DECISION DELEGATED TO DEVELOPMENT MANAGER

Application No: H19-0907-20 **Applicant:** Mr J Plater

Proposal: Extension to existing bungalow and creation of first floor in roof space.
New double garage with loft storage above.

Location: Sunleigh 125 Luttongate Gedney Hill

Proposed Double Garage
Scale 1:50

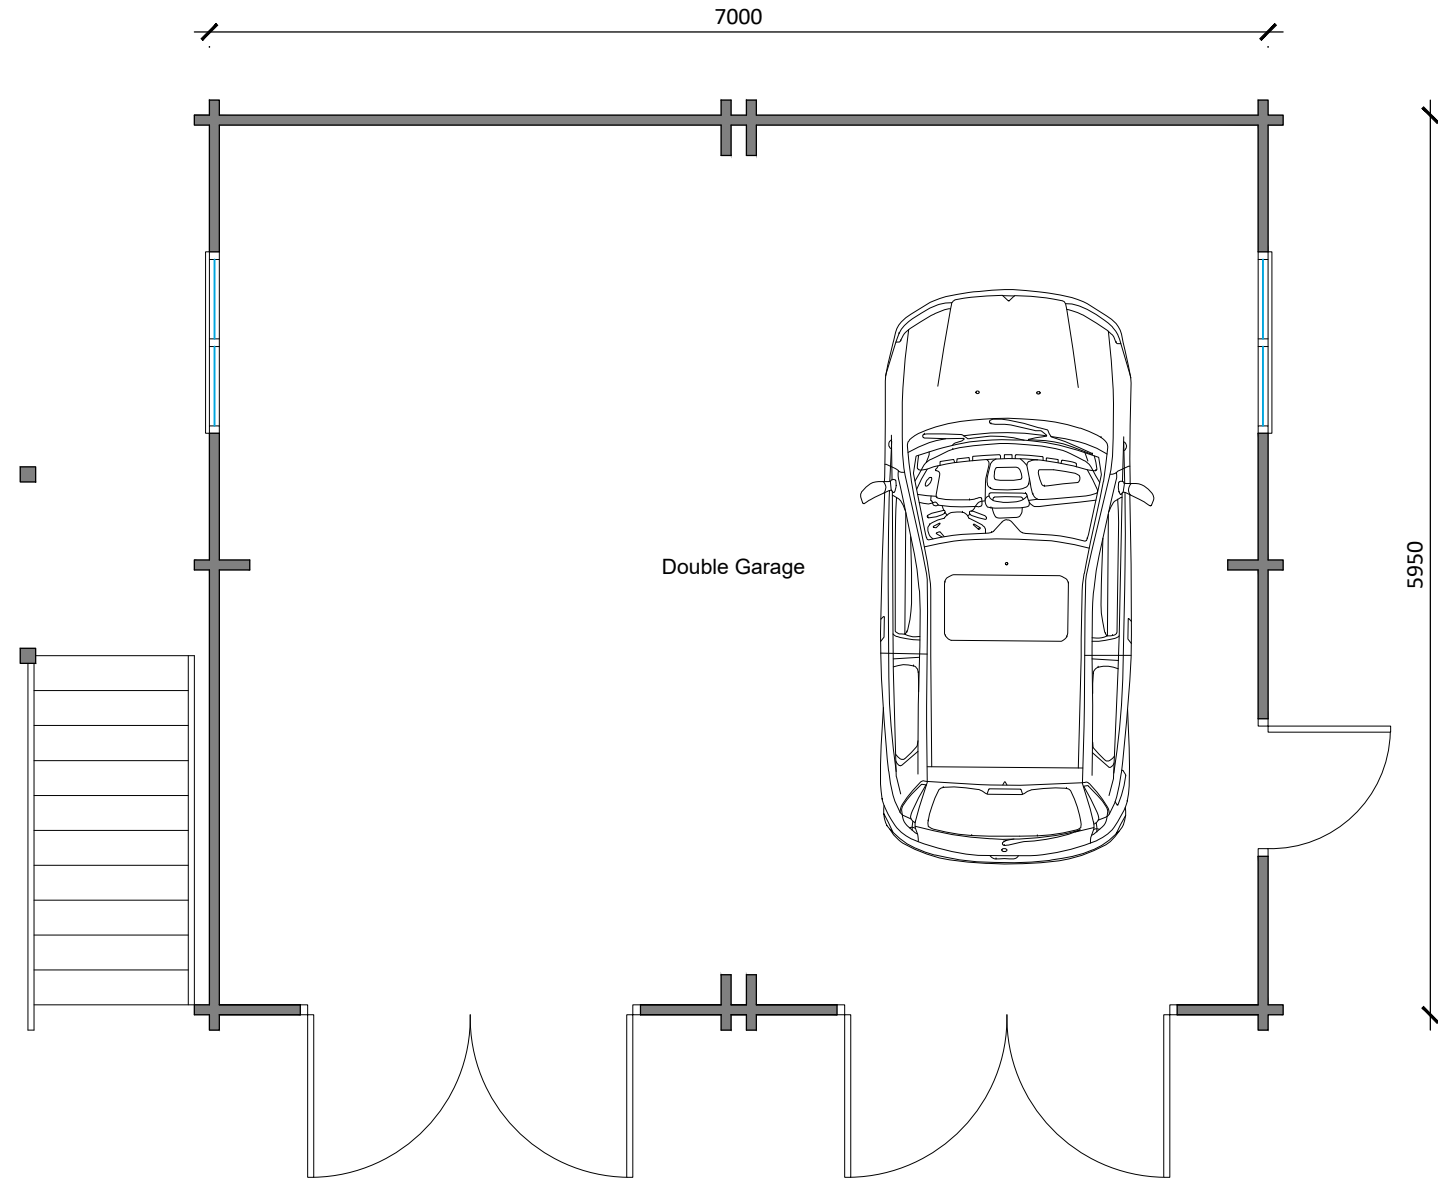
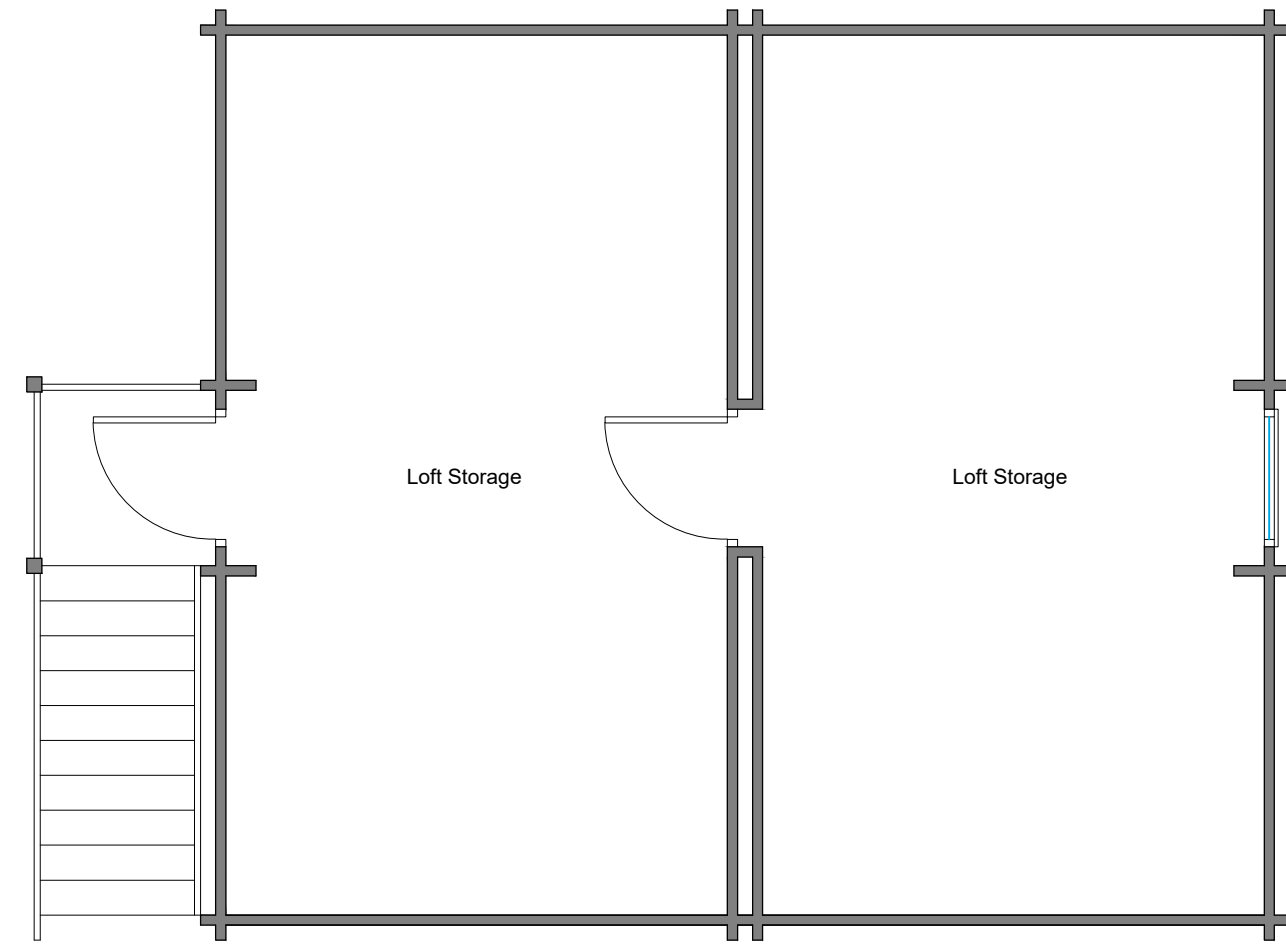
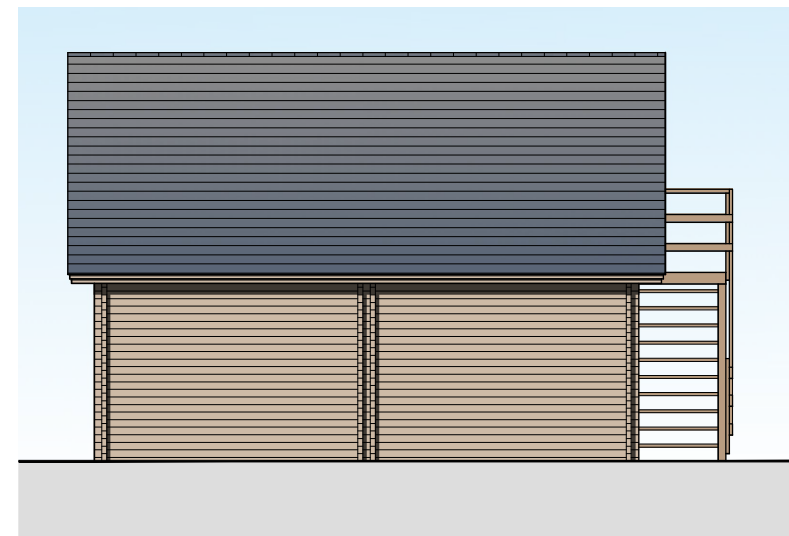
The detached garage will be 5.88 metres wide, 5 metres deep and 5.33 high. By reason of dimensions, this ancillary structure to the dwelling will appear commensurate with the main building. The garage will be erected 11 metres set back from the front boundary abutting the road and adjoining the driveway.

The proposals will increase the total number of bedrooms from 2 to 5. Three spaces for dwellings with 4 or more bedrooms should be provided within the curtilage. A garage can count as one space if it is 2.6m x 5.6m internal width.

The internal dimensions of the garage exceed these measurements. Therefore, two cars can be safely parked inside the garage and the third vehicle, on the drive area. The size and layout of the area is such that a maximum of two further cars could be parked on the drive with turning point to reverse and egress the site in a safe and forward manner.
